MMC - Initial Traffic Movement Permit Comments

Thu, Nov 8, 2018 at 1:46 PM

TITLE  
**SITE PLAN,  
LOWER CONGRESS,  
CONGRESS STREET  
EXPANSION**

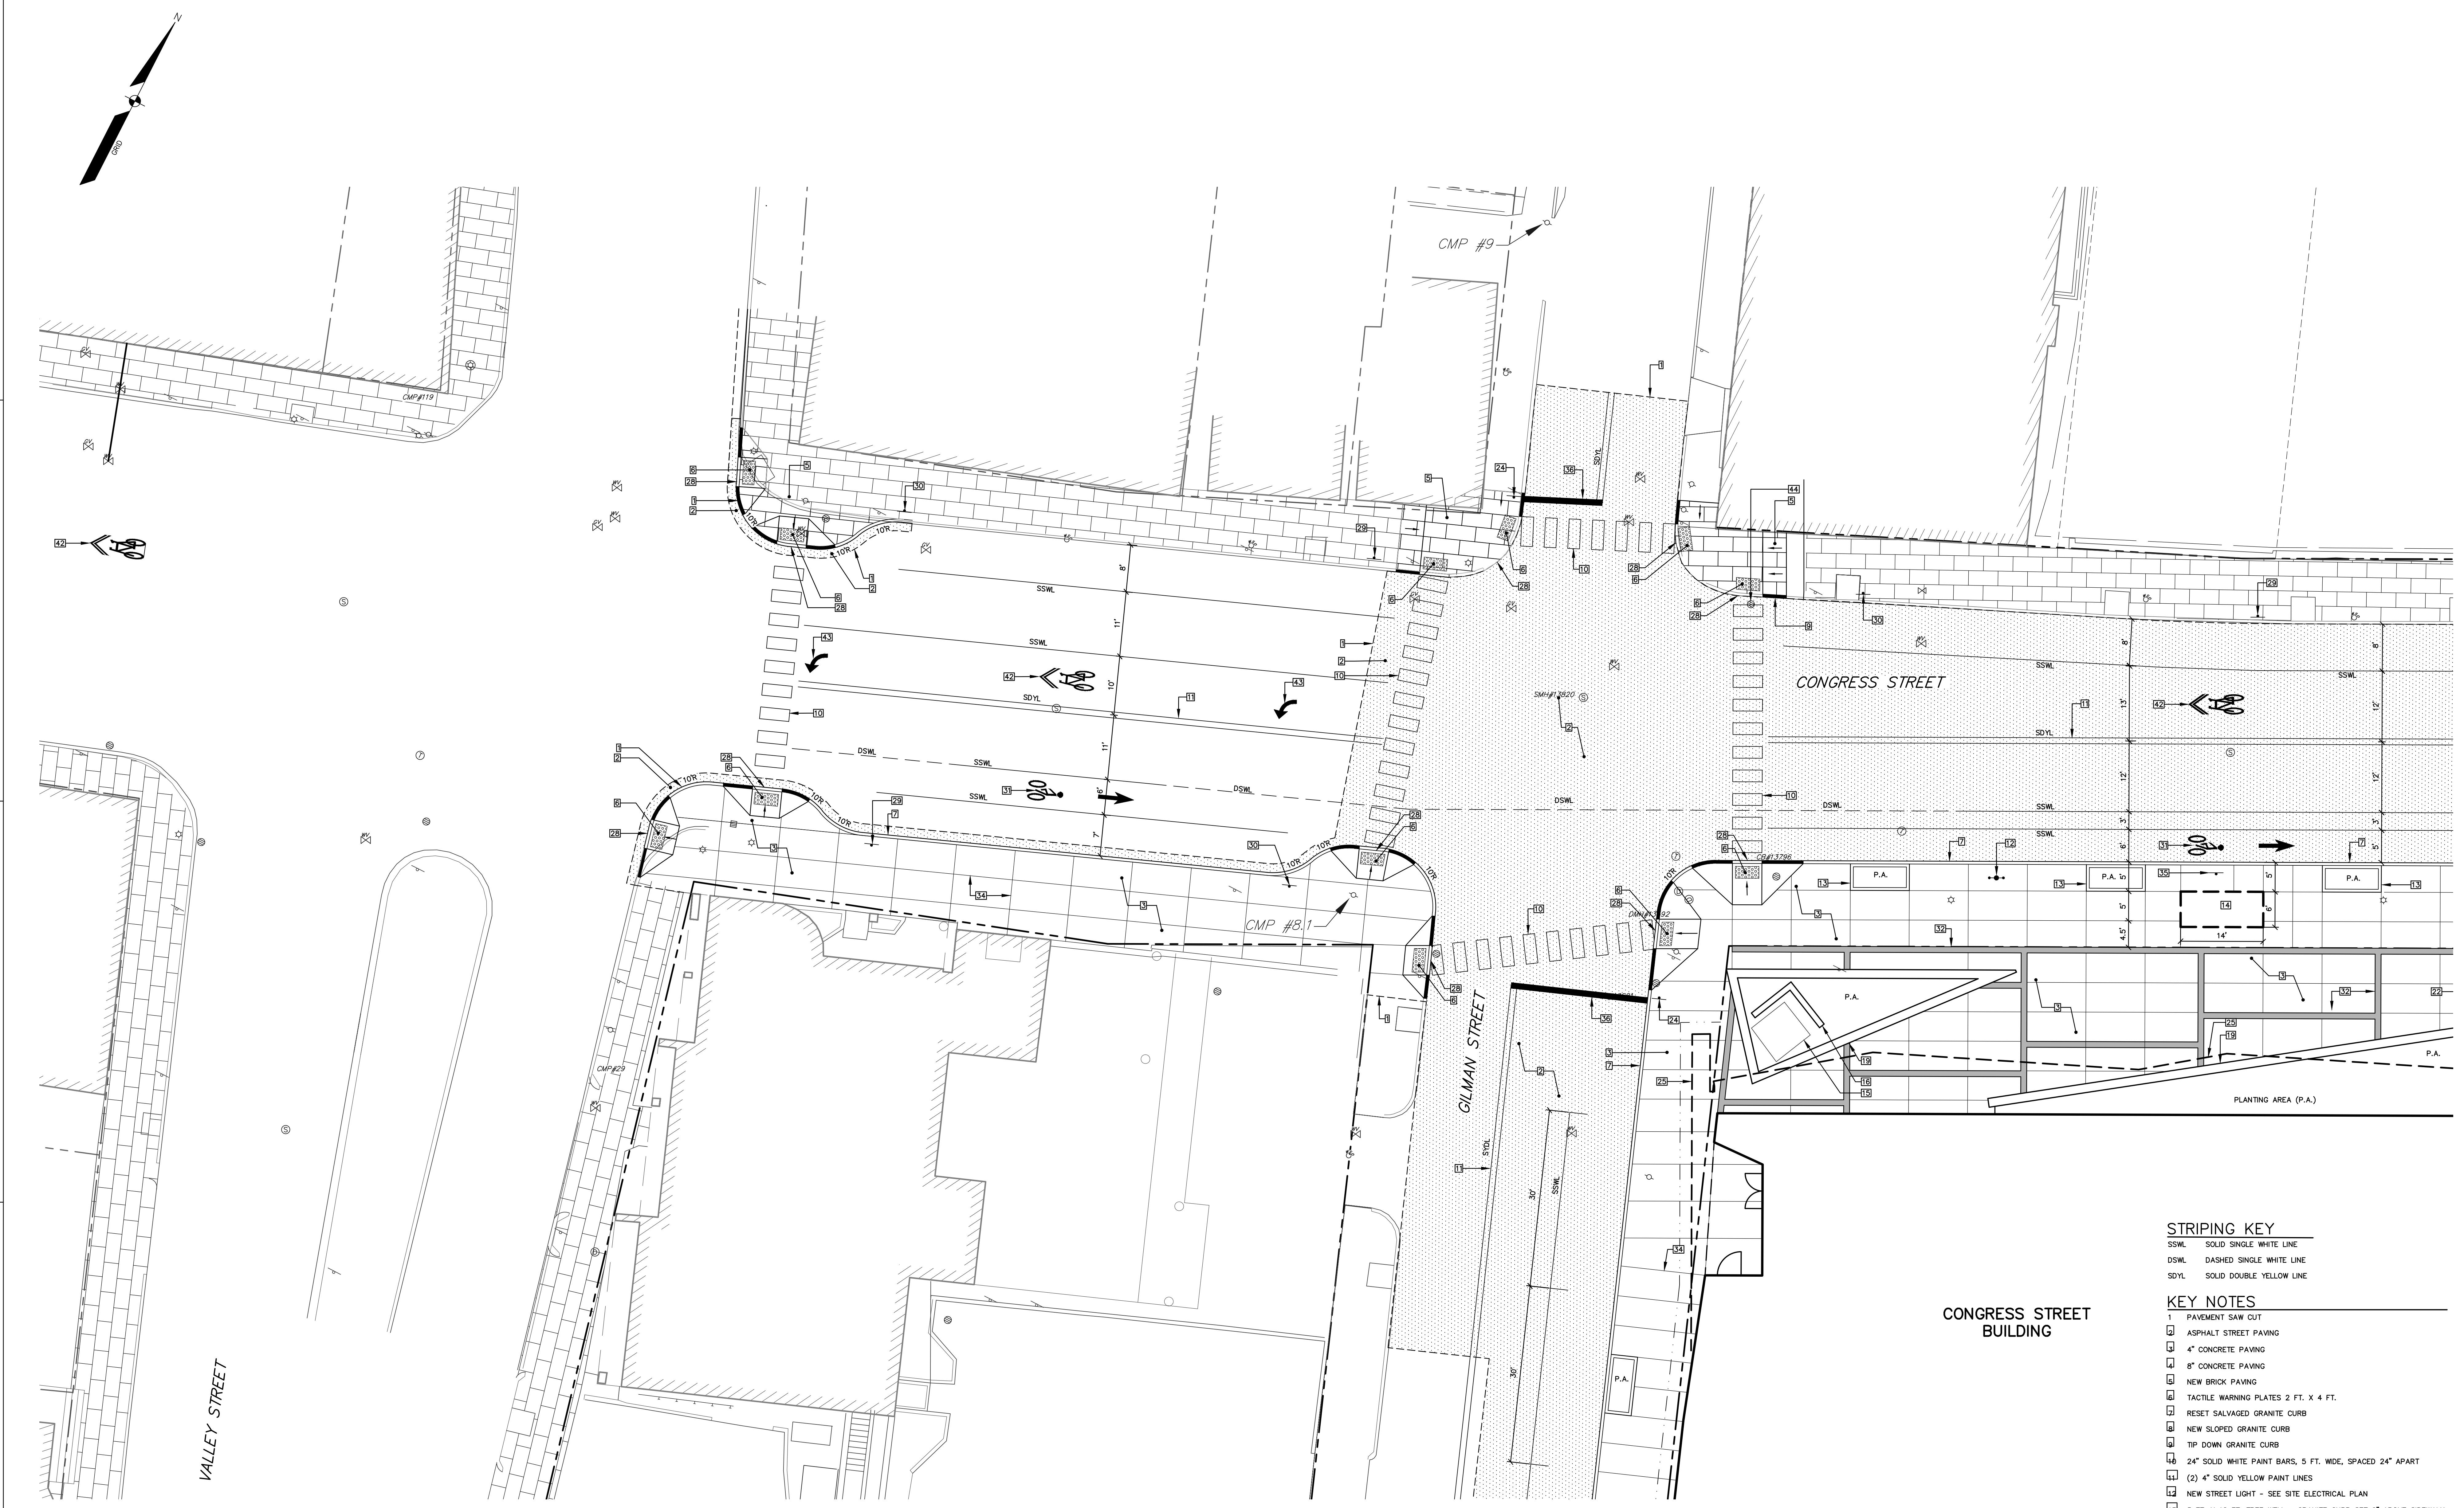
I concur with Tom's comments. In particular, I share concerns with the non-urban nature of a three-lane cross section fronting MMC and implications for vehicle speed, as well as a need to evaluate and recommend future pedestrian accommodations with an unsignalized Congress at Valley.
